The Tivetshall Parish Council Registration Application

Reference [REDACTED]

East Pye Solar Project

CONCEPT SURFACE WATER DRAINAGE
BESS AND 400KV PROJECT SUBSTATION
BESS SITE

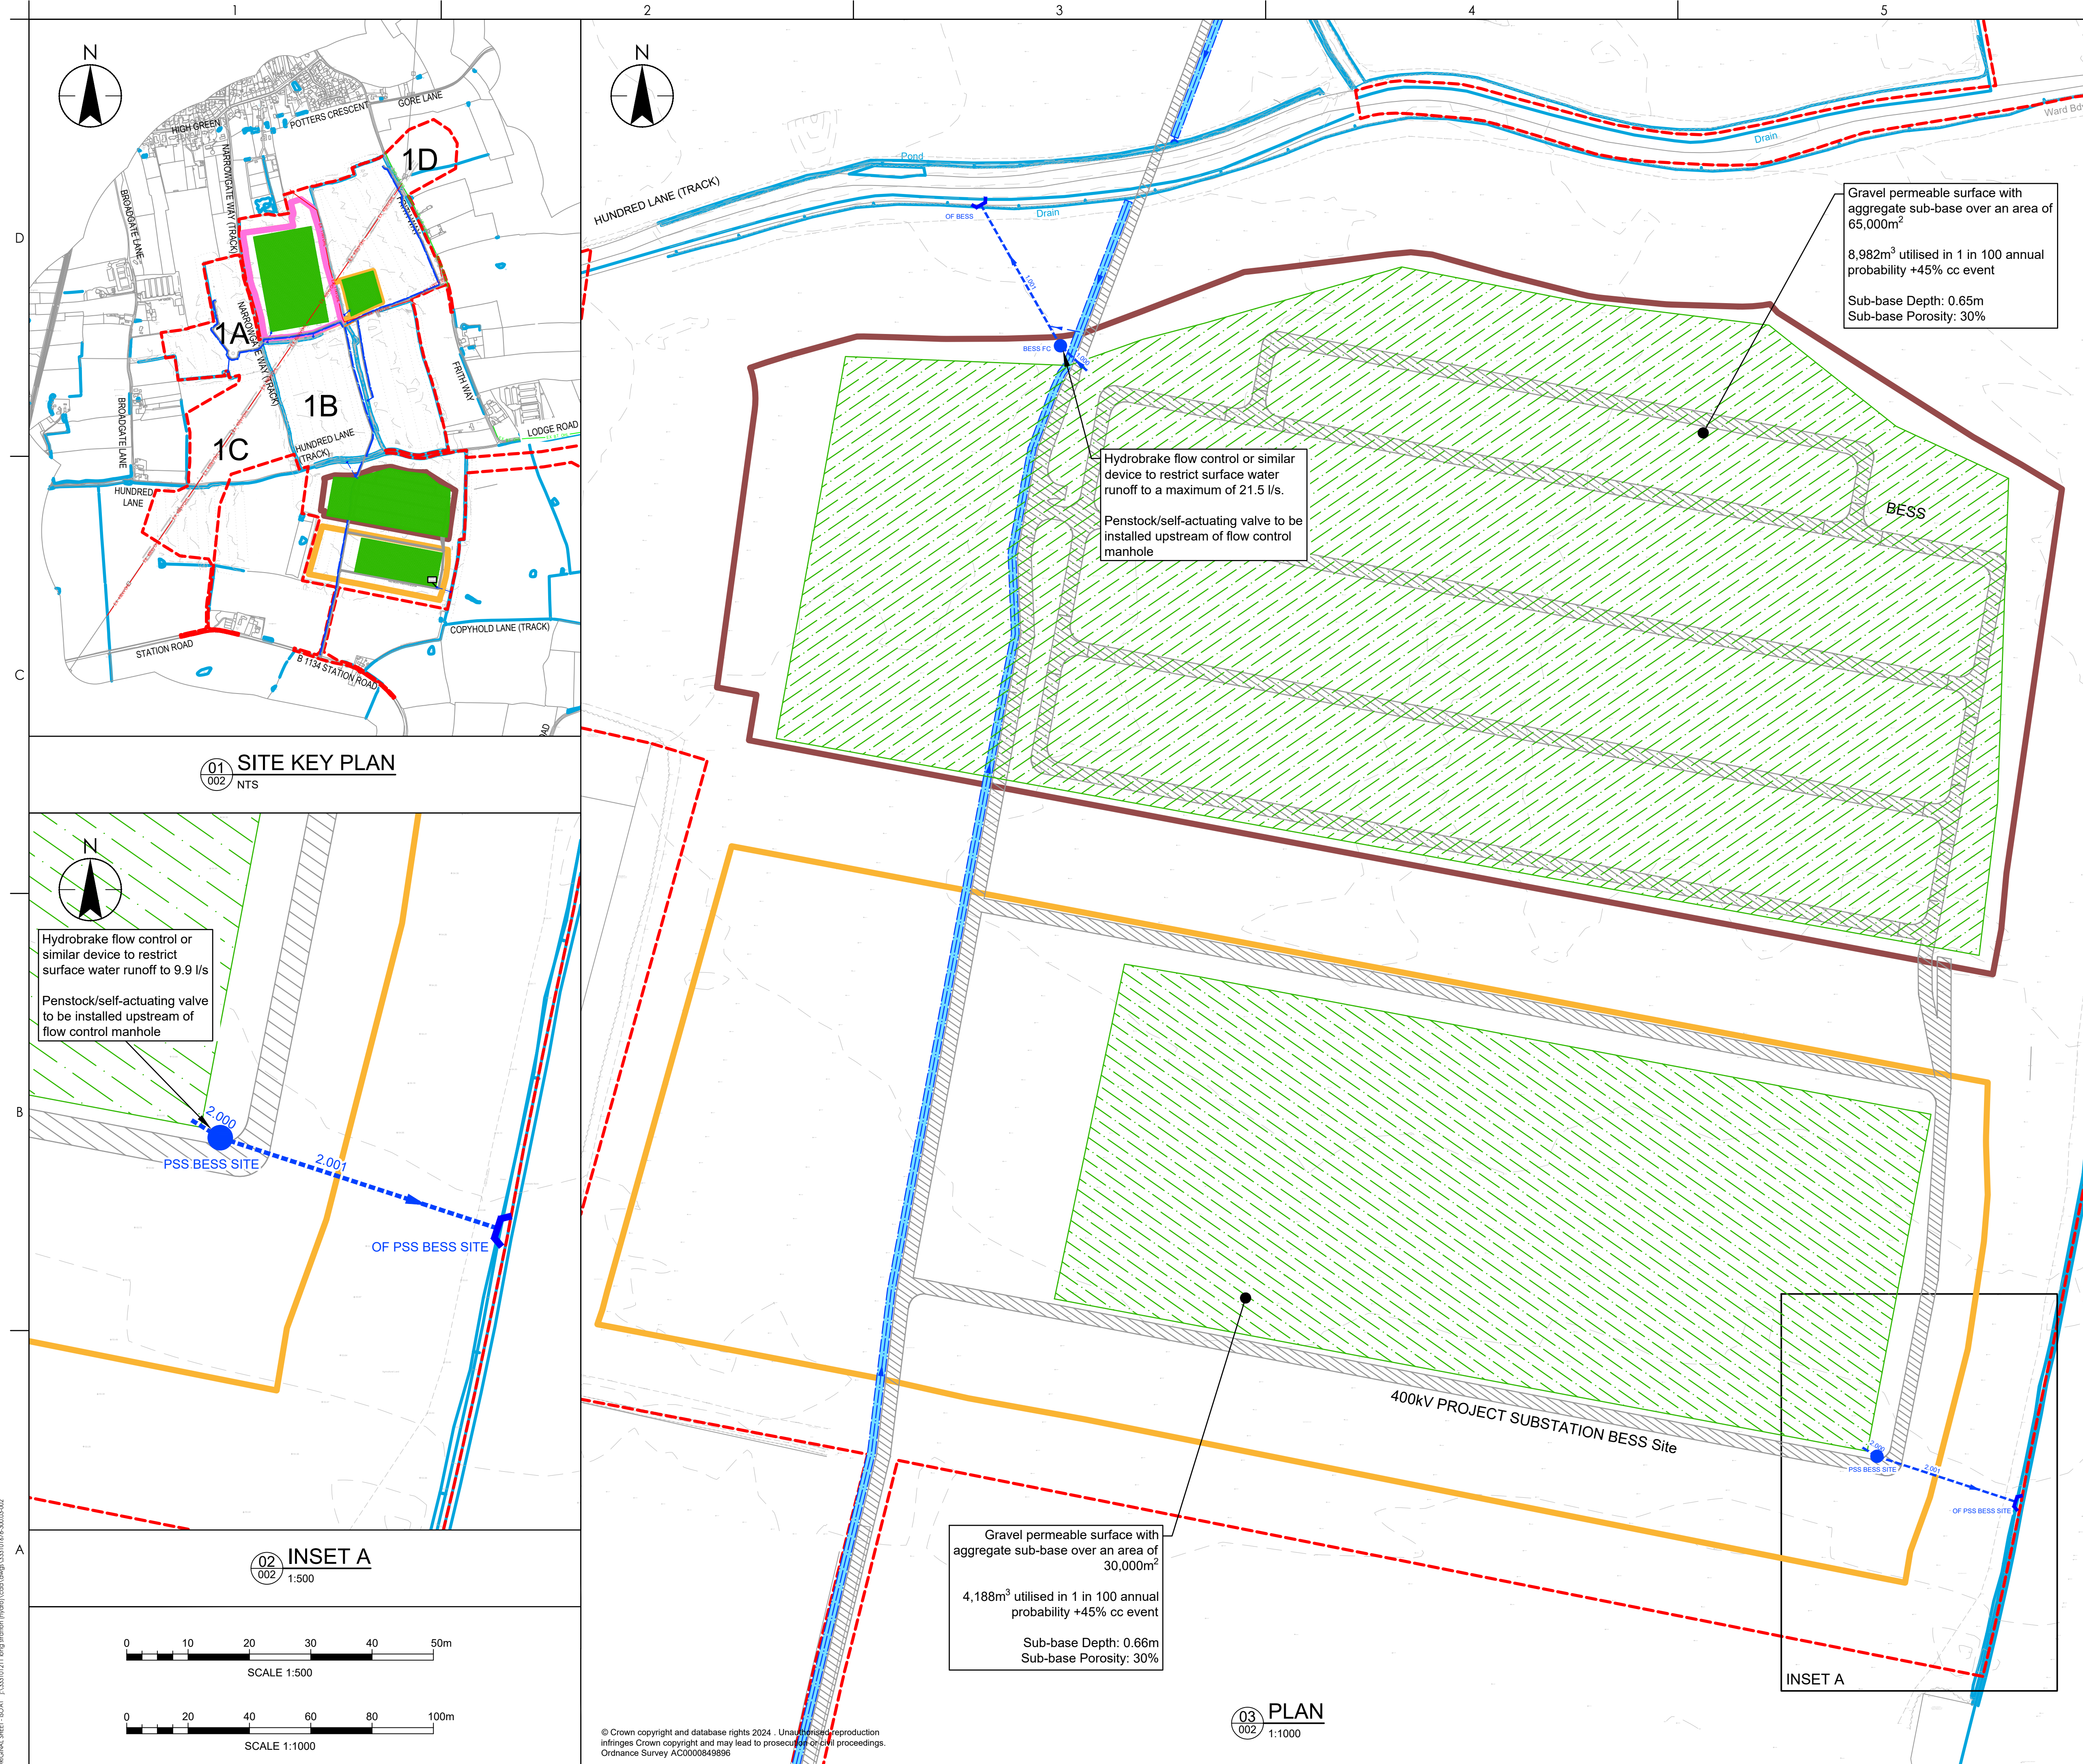
Homes, farmland and river tributaries– there is no consideration of the development exacerbating water surface water drainage issues on land and homes as well as the risks of contamination to the underground water sources. There needs to be tighter scrutiny of the impact on soil, drainage of land sites 2A, B and C as well as the access roads and cable corridors. Anglian Water is the company for our parish. Water pressures and costs in recent years particularly the hotter summers increases the desire to obtain water from the private bore holes. Residents and farmers are concerned at the potential for contamination and thereby removing the suitability for use on land, livestock or domestic use.

The BESS is of great safety concern. The project identifies a fire-water facility. It does not include any inspections by the Fire Service during the lifetime of the project to ensure ongoing compliance with a viable water supply is always stored on site. There is no protection of ground water supplies in the event of a fire requiring water cooling control.

BESS-specific safety, lighting, fire-water and emergency access parameters need checking

Has the BESS site (including the project substation) been assessed against worst-case fire, smoke plume, contaminated fire-water runoff, emergency access, separation distances, water supply, lighting, CCTV, noise, fencing, drainage and ecological receptors? Has the assessment considered cumulative risk from the BESS, substations, pylons, access roads and nearby residential/public receptors together?
